Submission ID: 32640

Title  
**SWEPT PATH ANALYSIS - GOLDWELL LANE BEND**

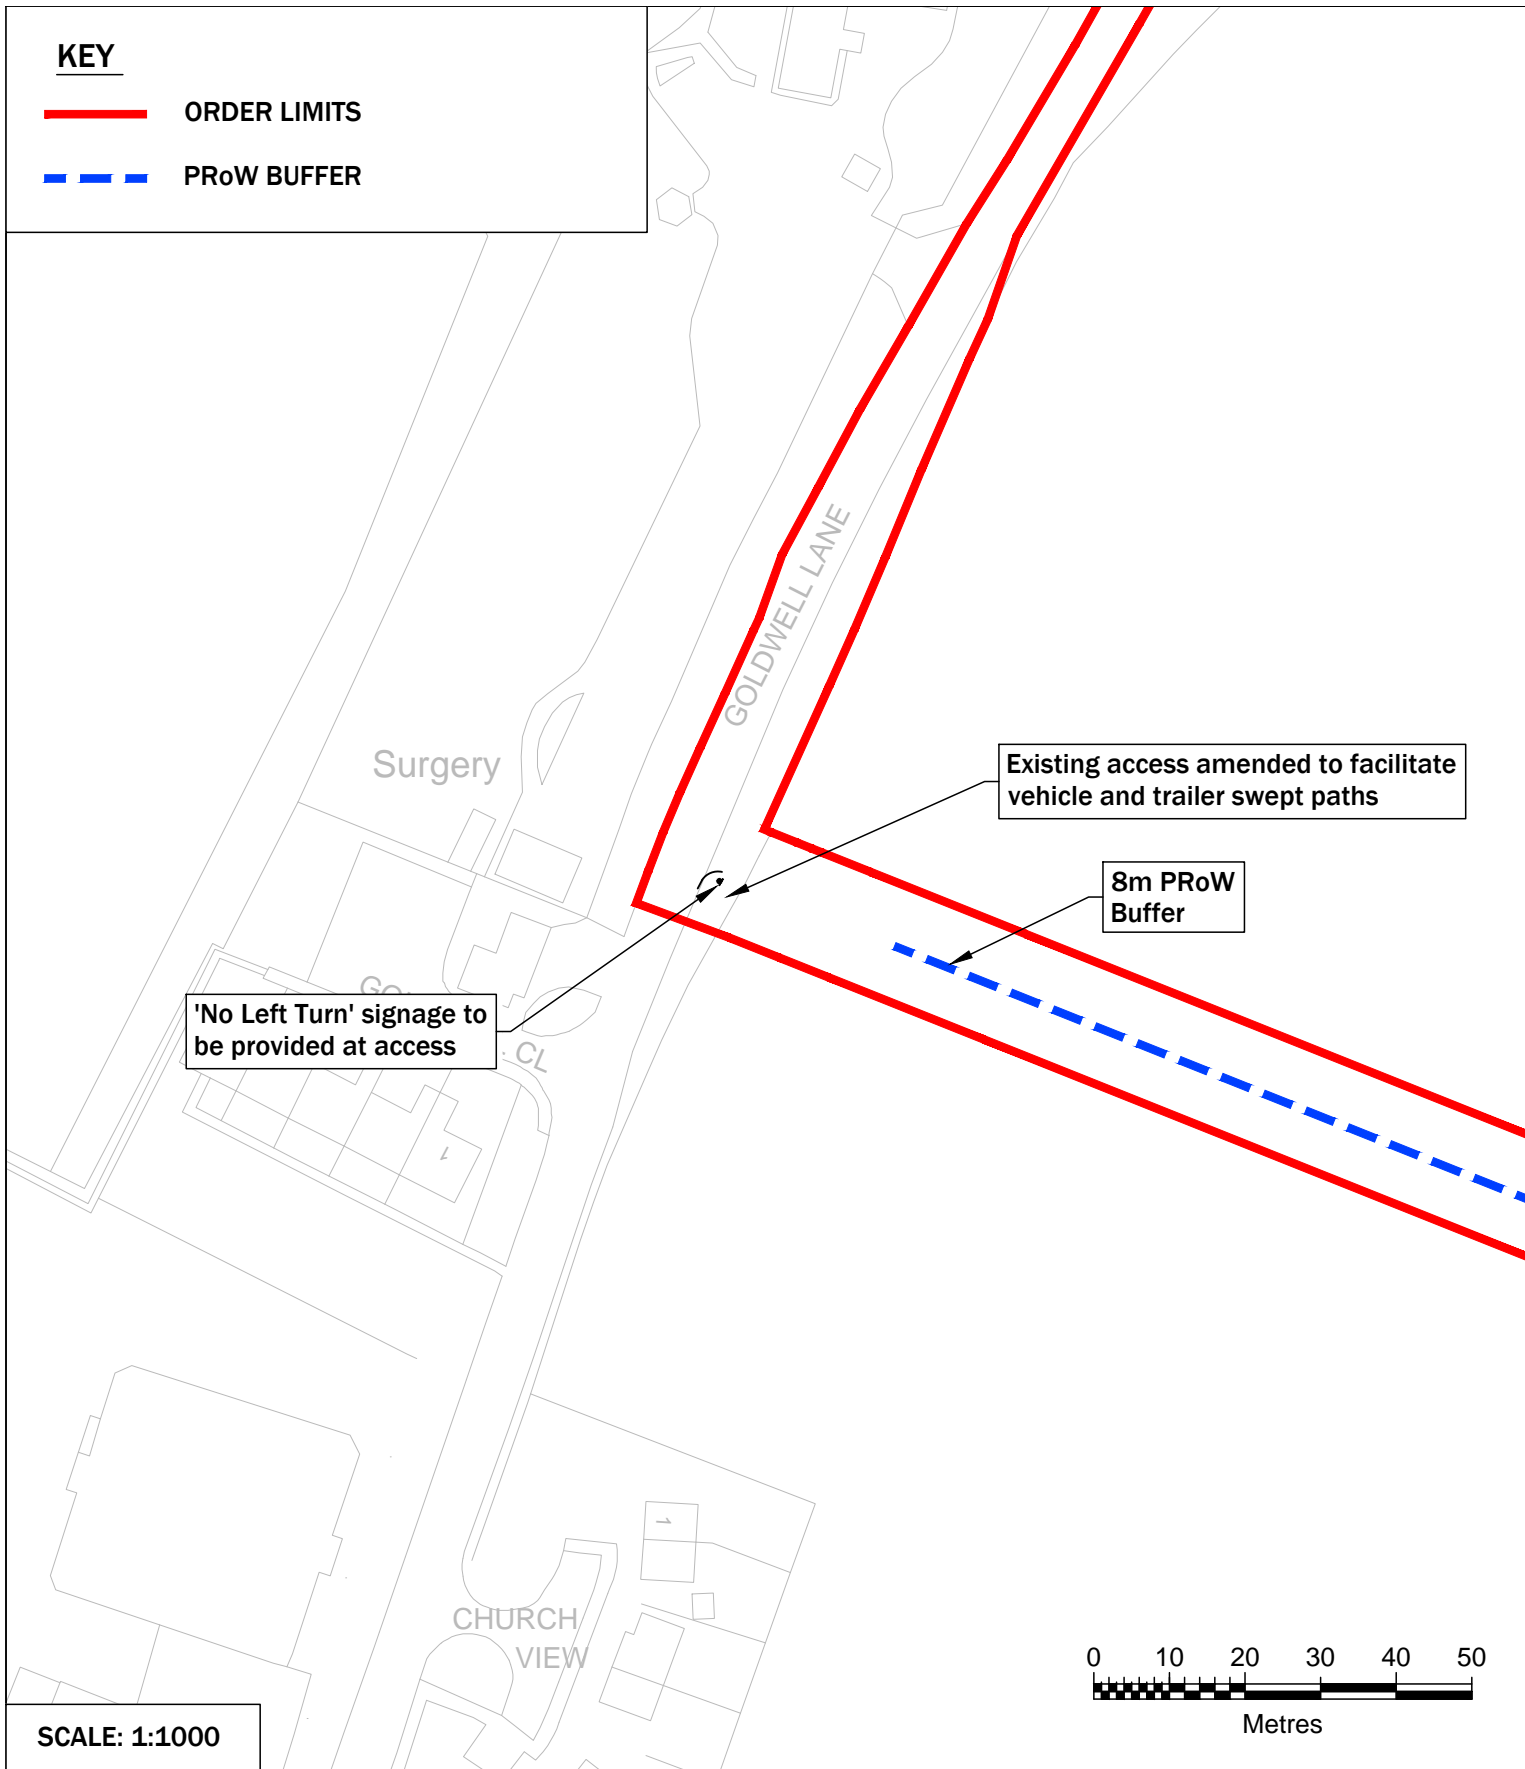
The disruption and risk to the residents on Goldwell Lane and the users of this road will be immense. I understand that it is to be used for access to the Eastern block on the plan which will produce only a small percentage of the overall energy output and be on good agricultural land . Many badger sets exist on these fields.
